**From:** [REDACTED]  
**Sent:** 25 February 2025 21:28  
**To:** Planning  
**Subject:** Planning Application No: 3/2025/0077 and 3/2025/0085

We would like to object to the above planning applications on the grounds of increase in noise and light pollution together with the increased traffic on already busy roads.

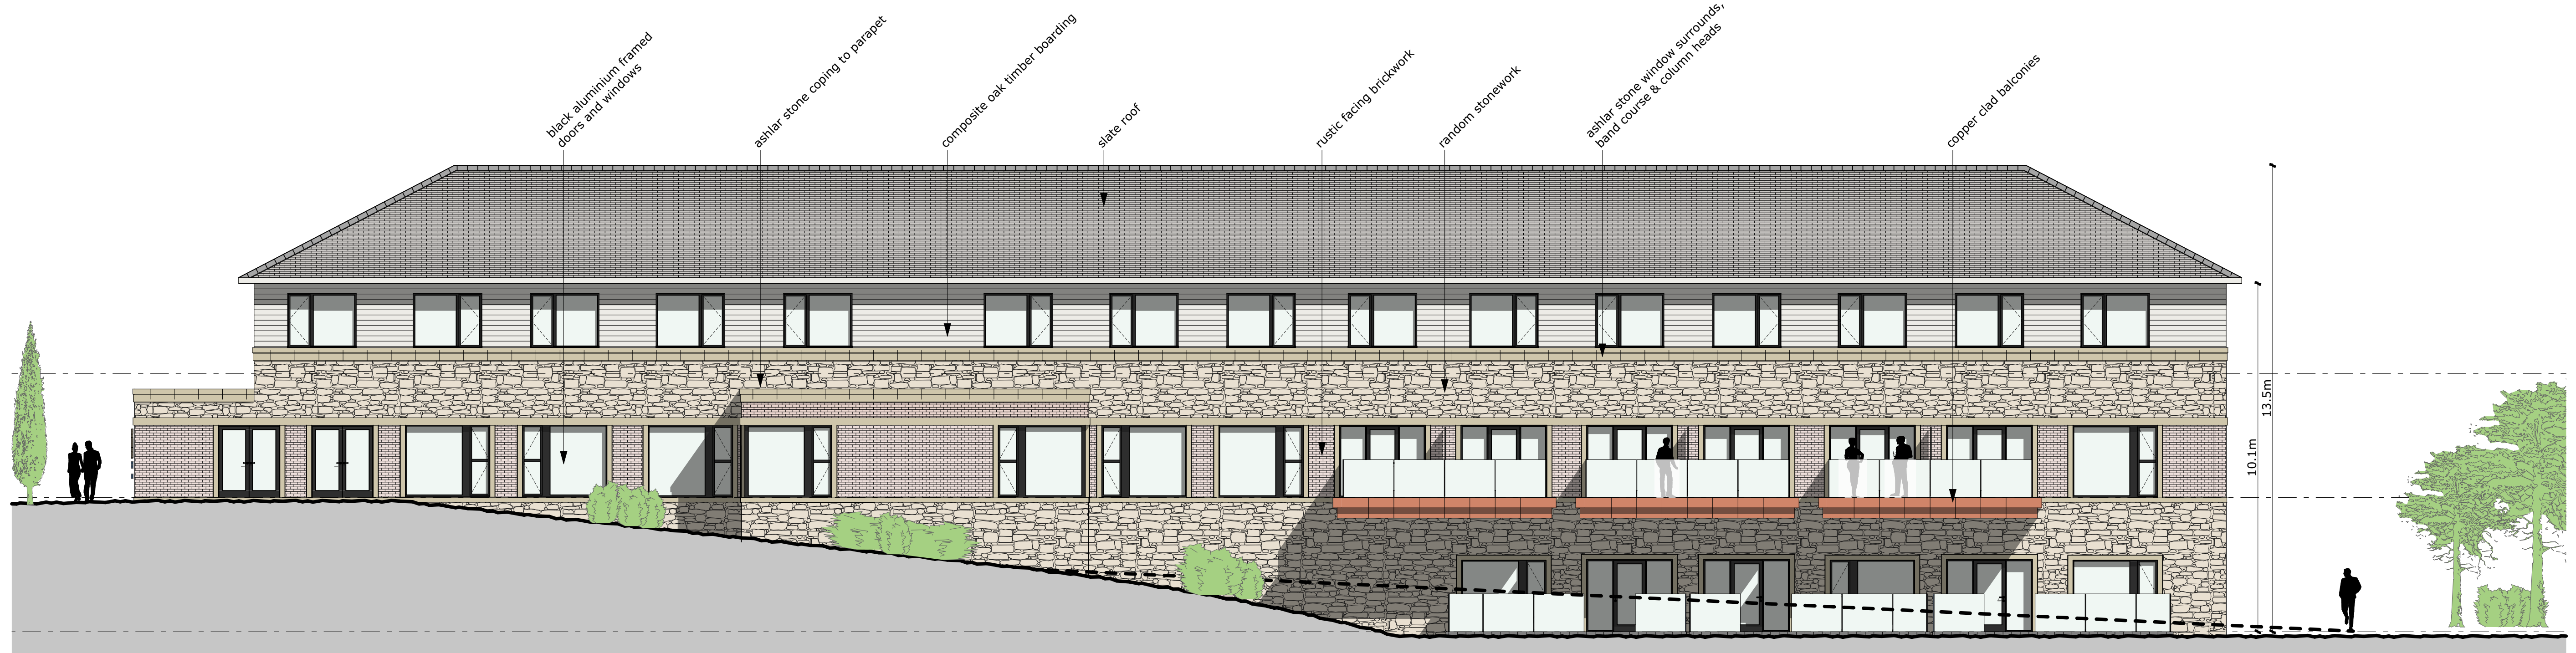
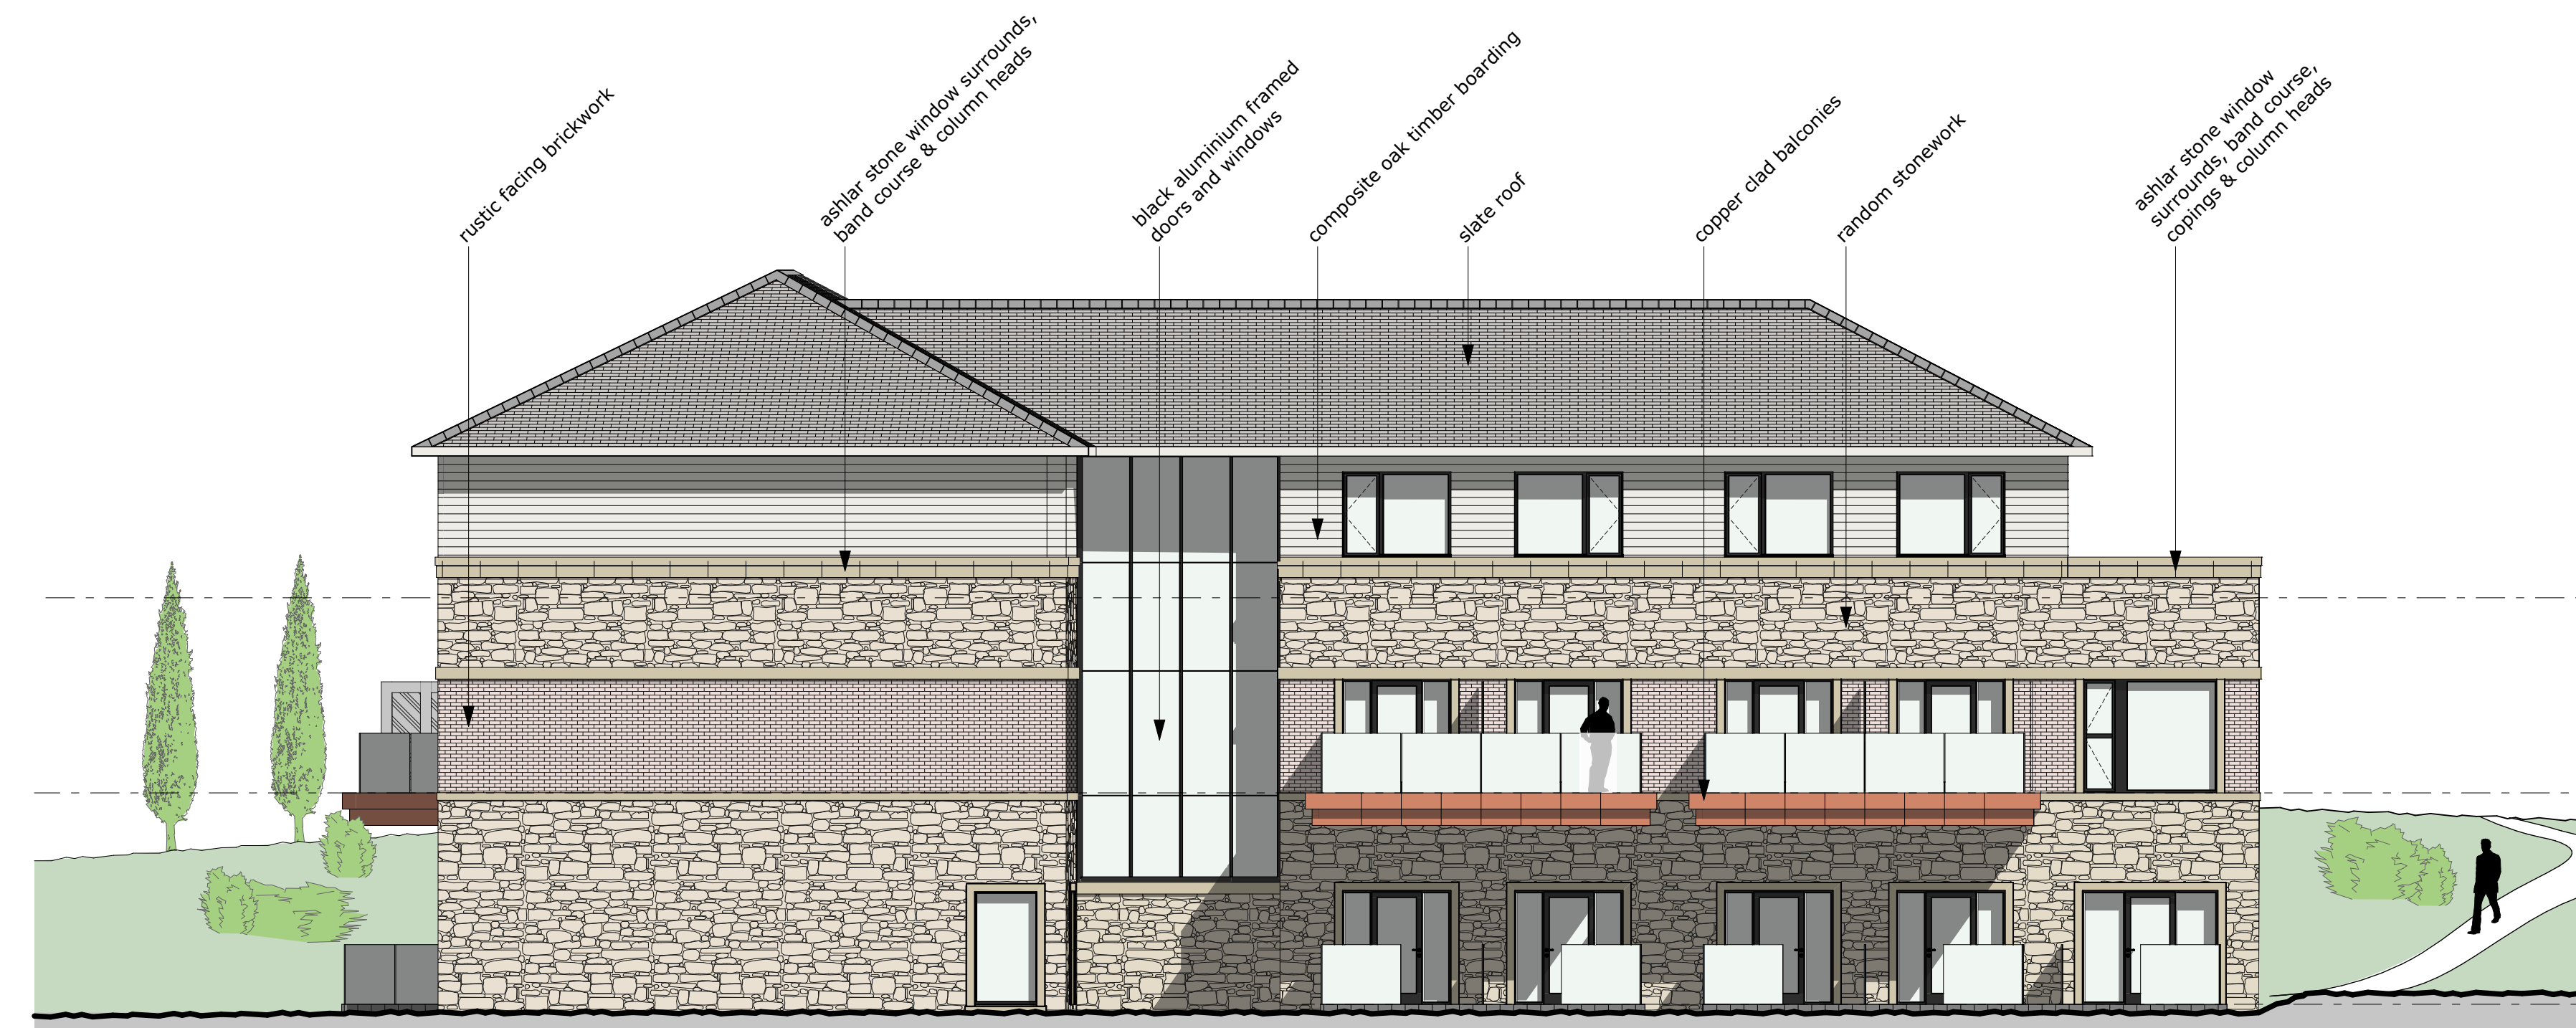
Would the proposed balconies on the bedroom wing also add to this noise and light pollution.
